From: Contact Centre (CRM) <contact@ribblevalley.gov.uk>
Sent: 13 December 2024 13:07
To: Planning
Subject: Planning Application Comments - 3/2024/0879 FS-Case-670373740

Planning Application Reference No.: 3/2024/0879

Address of Development: 27-29 Bawdlands BB72LA

Client: Boutique Homes Ltd		
Project: Proposed Alterations 27-29 Bawdlands Clitheroe		
Dwg title: Proposed Front Elevation		
Scale @ A3: 1:50	Date: 18.10.24	Drawn by: PD
Drawing no. 1569 - 2 - 04		Rev. -

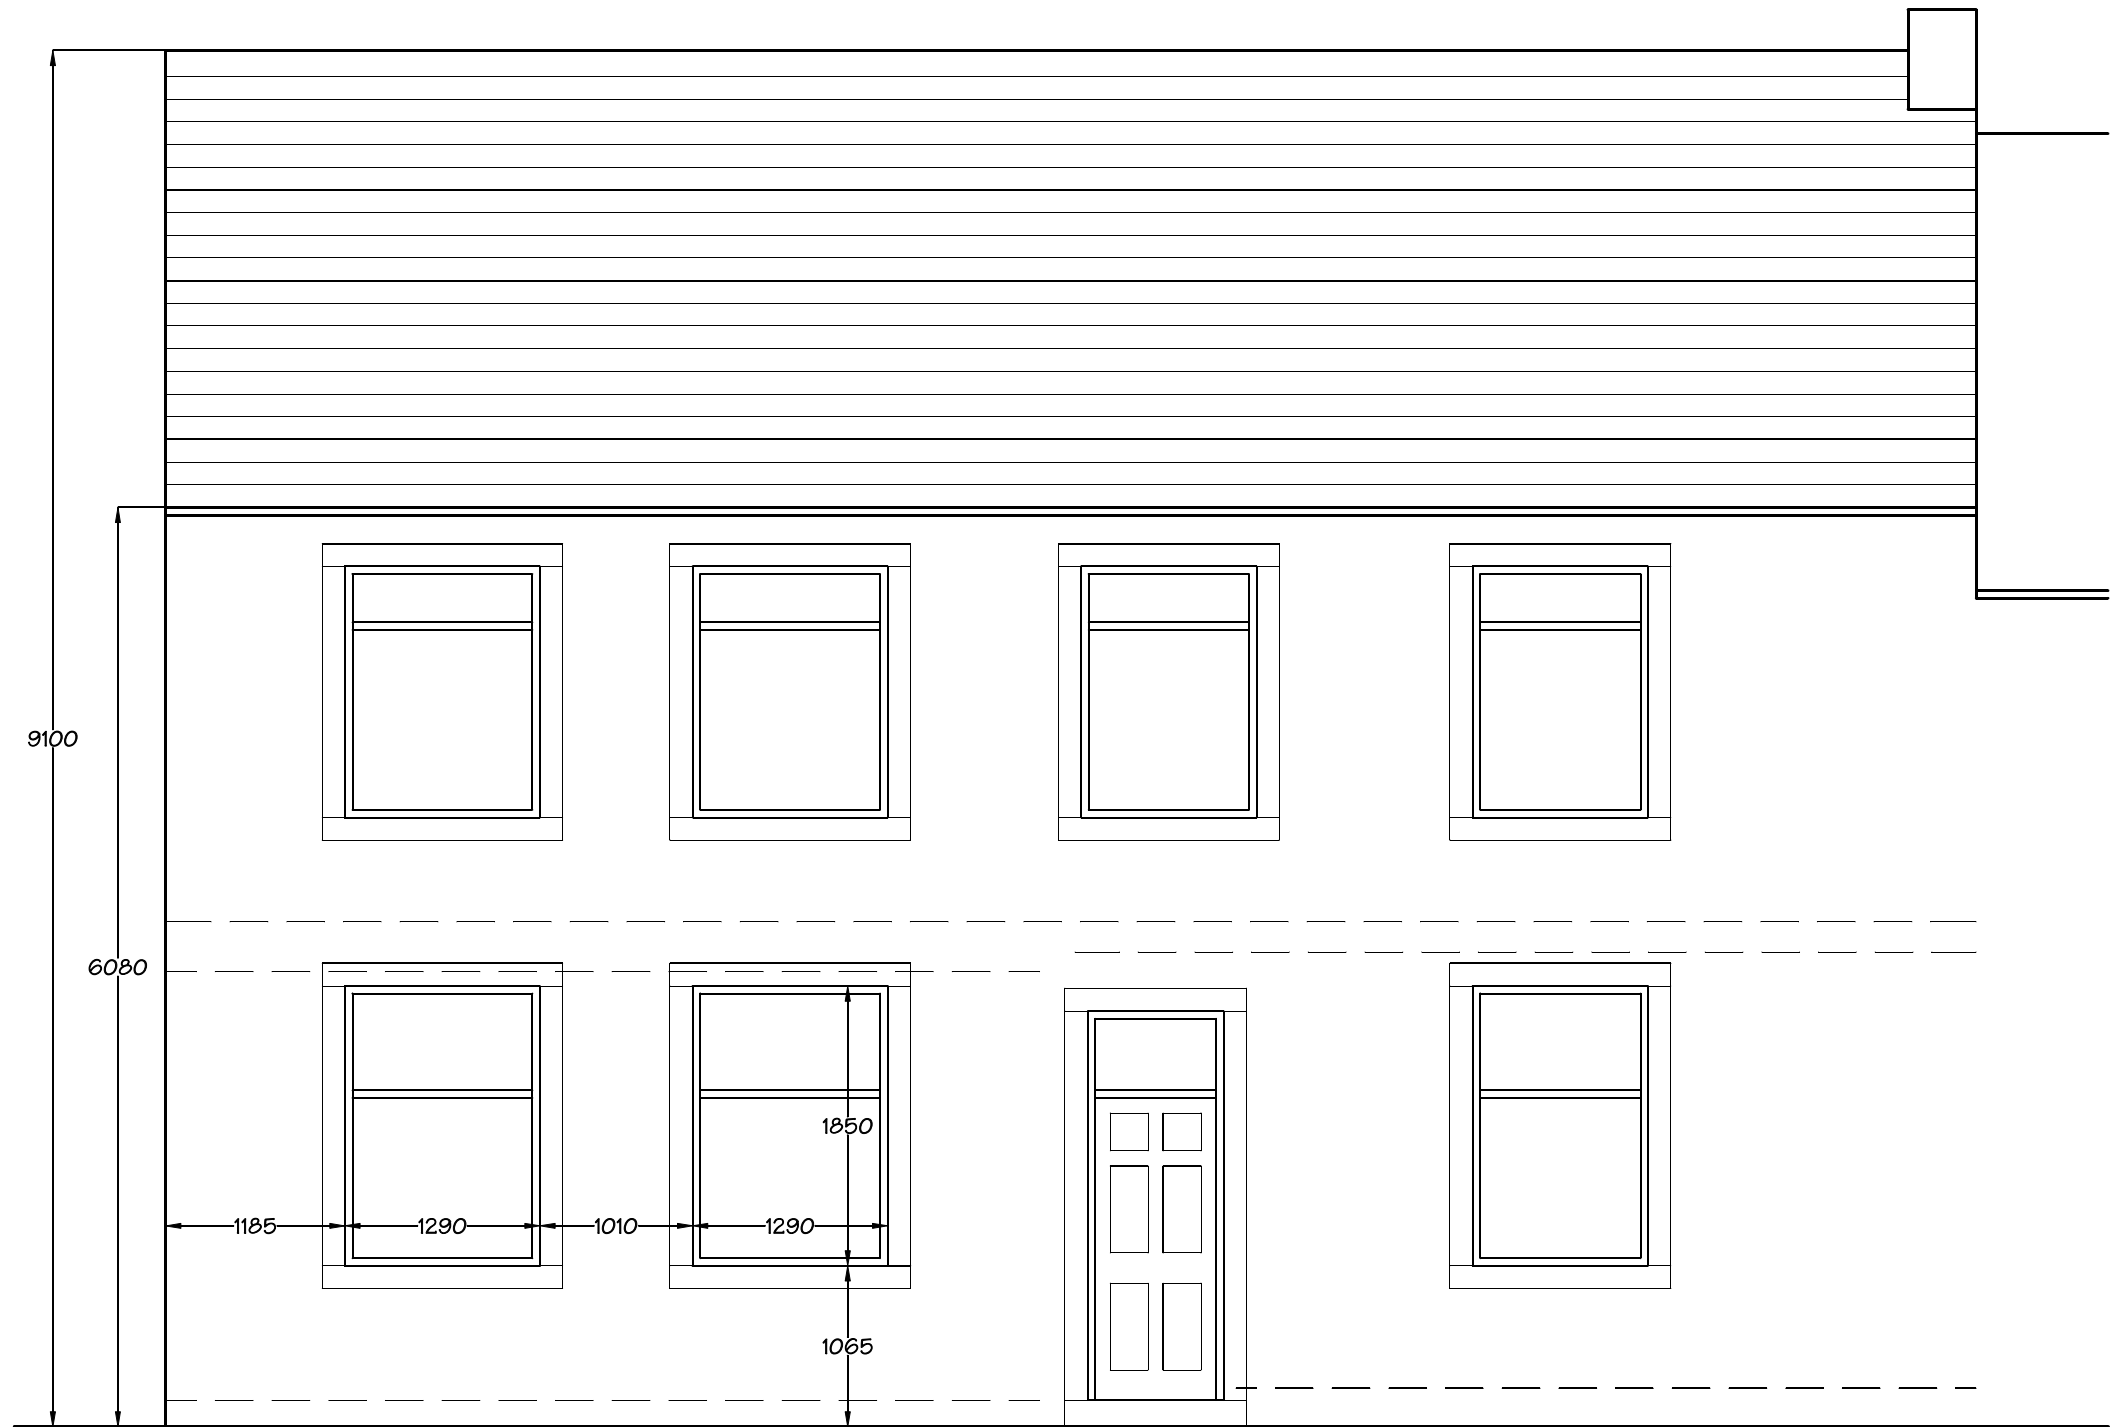
Removal of the shop front would be at detriment to the character of the building and surrounding area whilst unsympathetic out of keeping and inappropriate to the original historic design of the building. Furthermore, as suggested earlier not in keeping with proposed intended use.

Client: Boutique Homes Ltd		
Project: Proposed Alterations 27-29 Bawdlands Clitheroe		
Dwg title: Proposed Side Elevation		
Scale @ A3: 1:50	Date: 05.06.24	Drawn by: PD
Drawing no. 1569 - 2 - 06		Rev. -

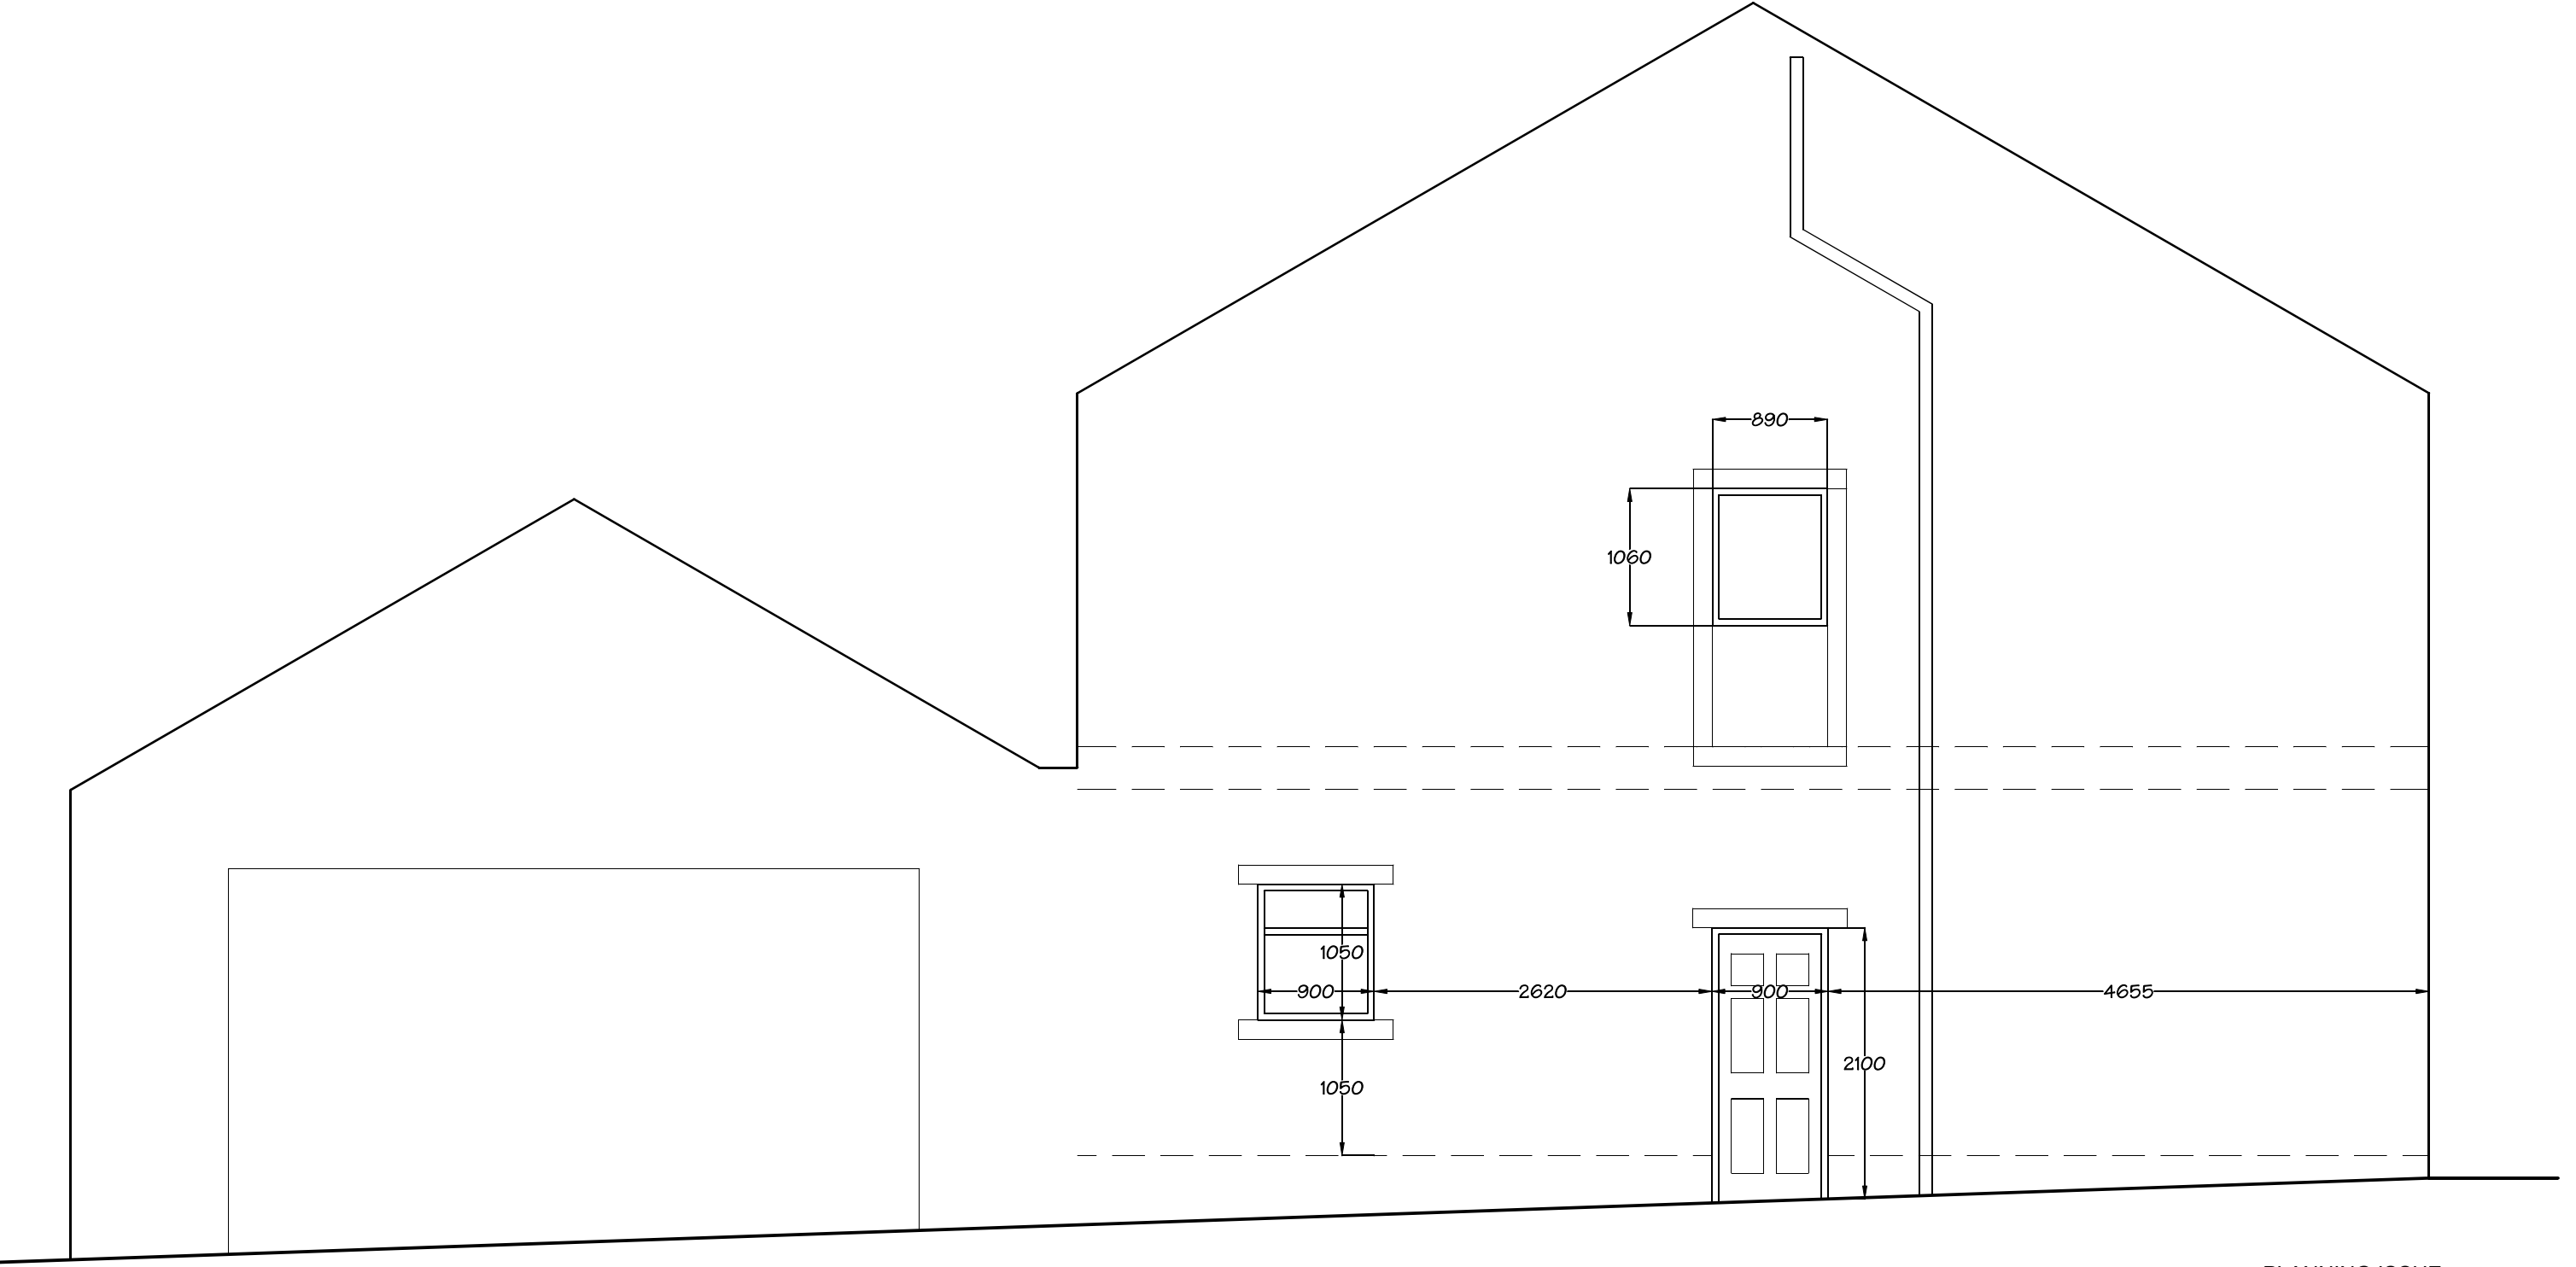
Comments: We have here a further example of attempting to make a plan fit an earlier application which has already been rejected and has gone to appeal. The work has already been carried out with the potential for problems which has been previously highlighted. The new door and window are not sympathetic with the original building. The door has 3 steps down to the public footpath; this would make it difficult for people with mobility problems to get in or out. If this door is to be an exit to have refuse bins emptied then 3 steps may present a problem. It could also lead to bin been left on the street permanently to save the bother of taking them in and out. This of course has implications. If the bins are inside then it may be difficult to exit in the case of an emergency. A door at this point could have further traffic implications at a site which is heavily used by traffic leaving and entering town. This also has the potential for further parking difficulties. A retrospective application which is of great concern.

The door which has been installed on the side of the building appears to be a regular domestic style door, it is not apparent that this is any type of fire escape door...surely there ought to be some form of fire escape in this building. My second concern is that the door is above three significant steps, if this is to be the door beside the bin and bike store there is now a manual handling issue, anyone residing there would have to carry bins over the door step and then down three steps every week for collection, will this happen or will bins just be left permanently on the pavement? The alternative is purple bags but again will they be emptied from one bin outside or will it become common practice to just put them out on the street or on the floor of the bin store room raising another issue of vermin attraction. Recent work appears to have been done on the drainage system, the demand of 8 additional toilets, sinks and showers as well as kitchen utilities surely has a much larger demand on a small section of the sewer, yet no additional man hole has been installed. It is my belief that the only man hole access is under the garage, a separate entity which is a business teaching children and adults martial arts, sewage issues could also destroy this business, any back up from the drains would be directly affecting children.

The amended plan suggests a door in the gable end of the building and a small new window. It is noted that this change to the building has already been done, despite planning not being passed. The doorway is small with steps.

Client: Boutique Homes Ltd		
Project: Proposed Alterations 27-29 Bawdlands Clitheroe		
Dwg title: Proposed Ground Floor Plan		
Scale @ A3: 1:50	Date: 18.10.24	Drawn by: PD
Drawing no. 1569 - 2 - 03		Rev. B

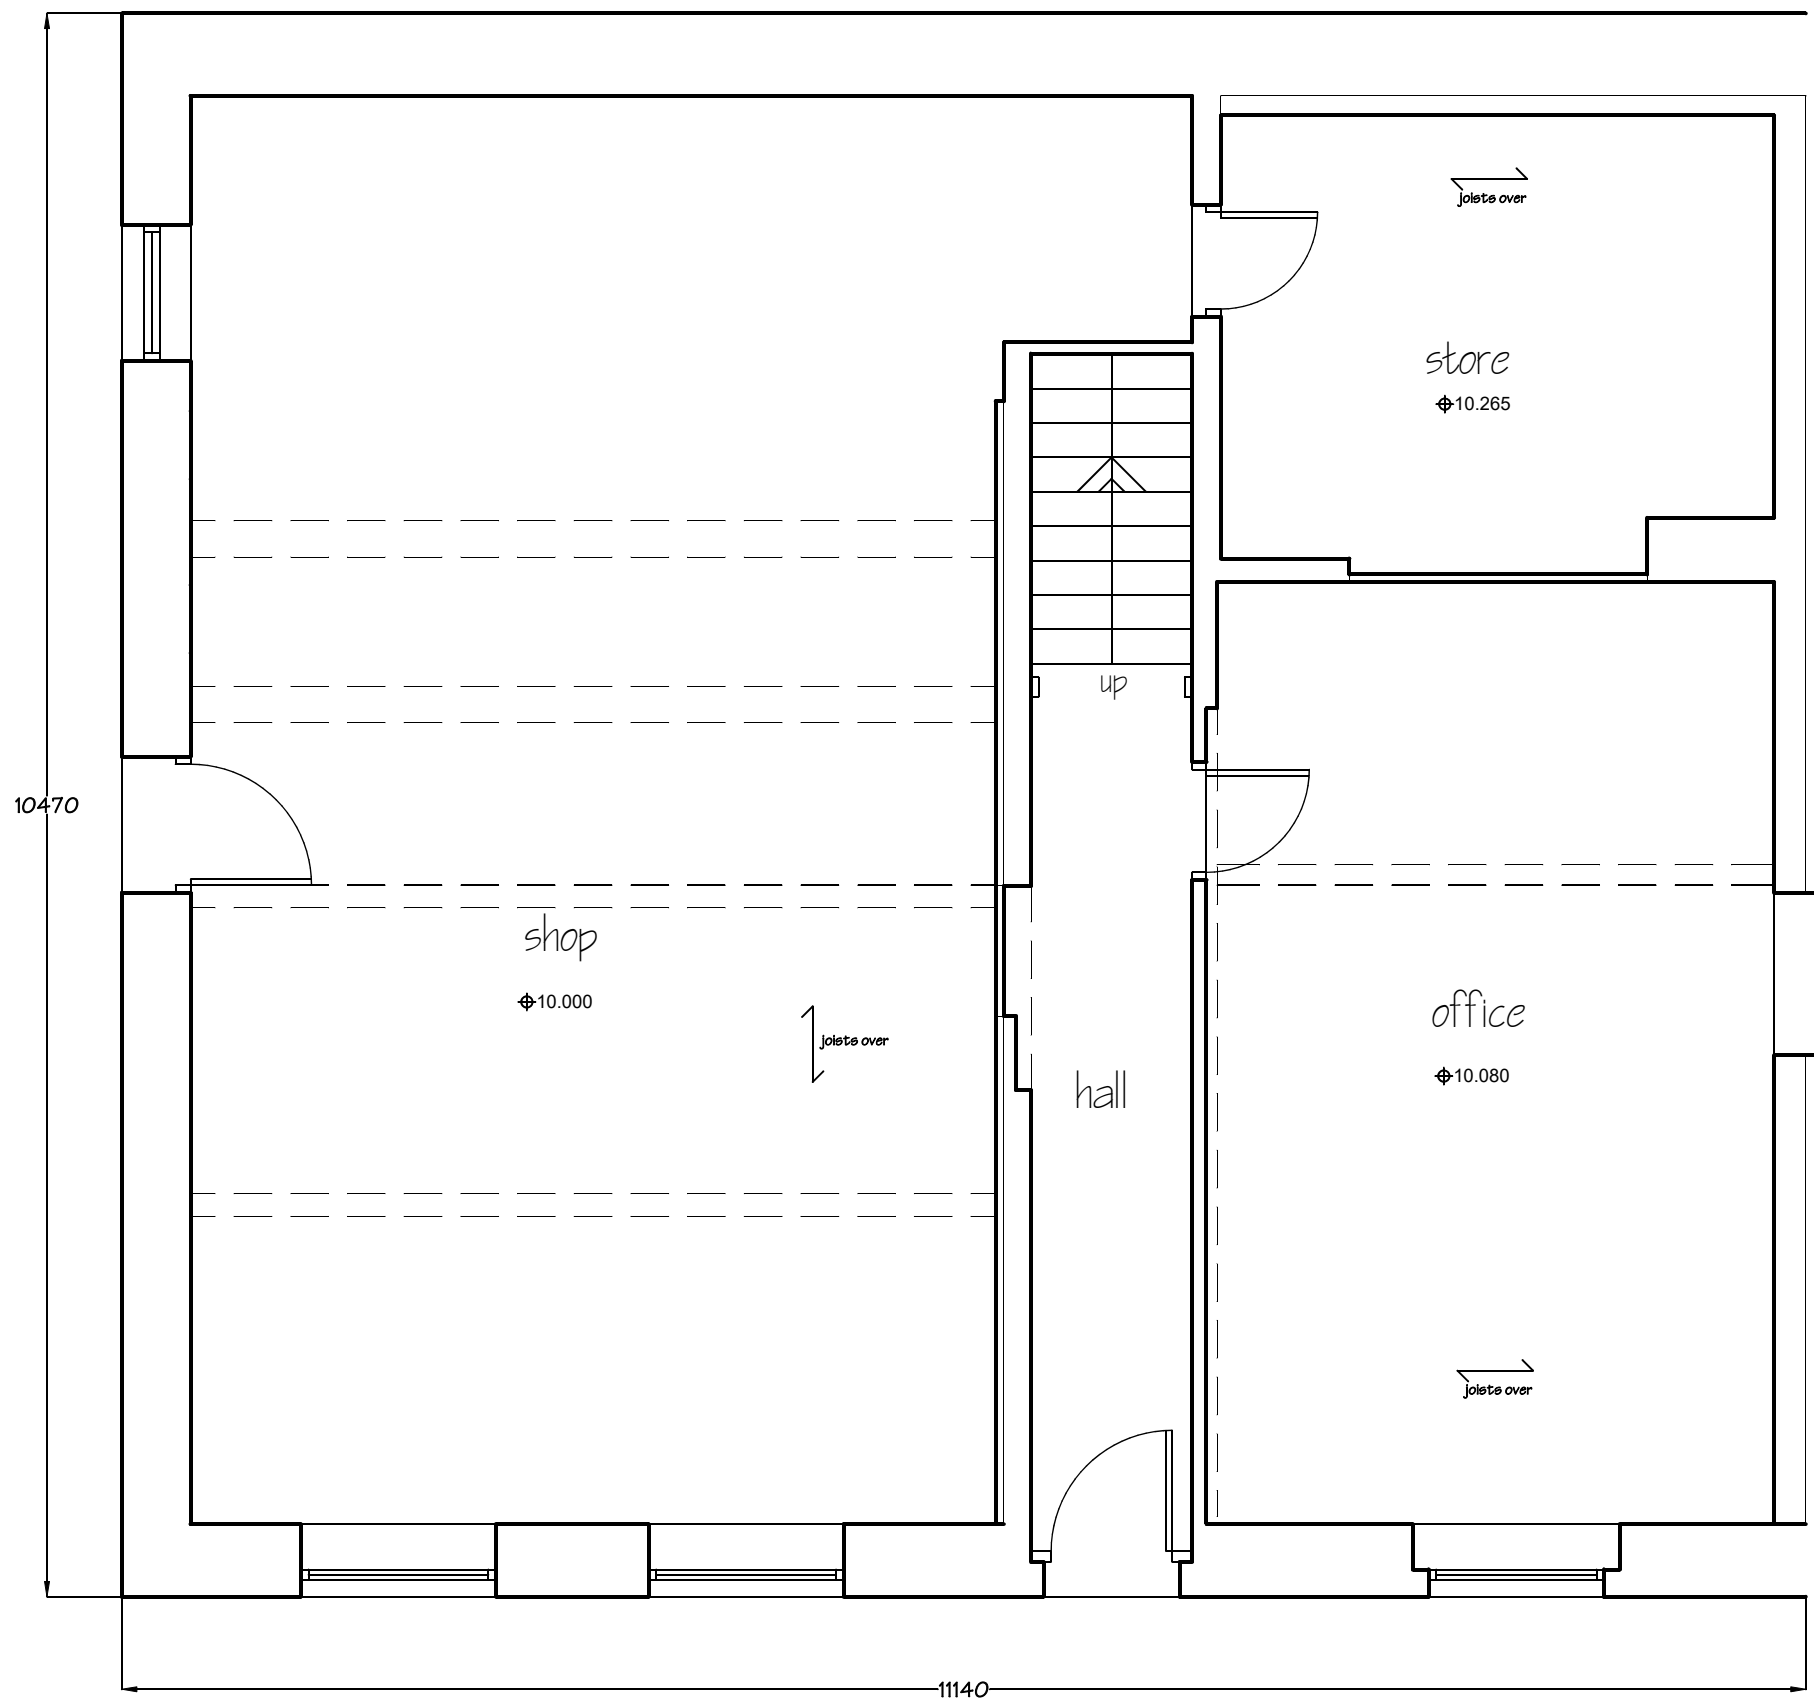
The application to change the ground floor is more suggestive of the original refused application (3/2024/0552). The amended drawings still bear no resemblance to the internal structure of the building in 27 or 29 Bawdlands and more in keeping with a bin and cycle store suggested in the former application. I believe this doorway would not meet fire safety standards for the proposed use of a shop.
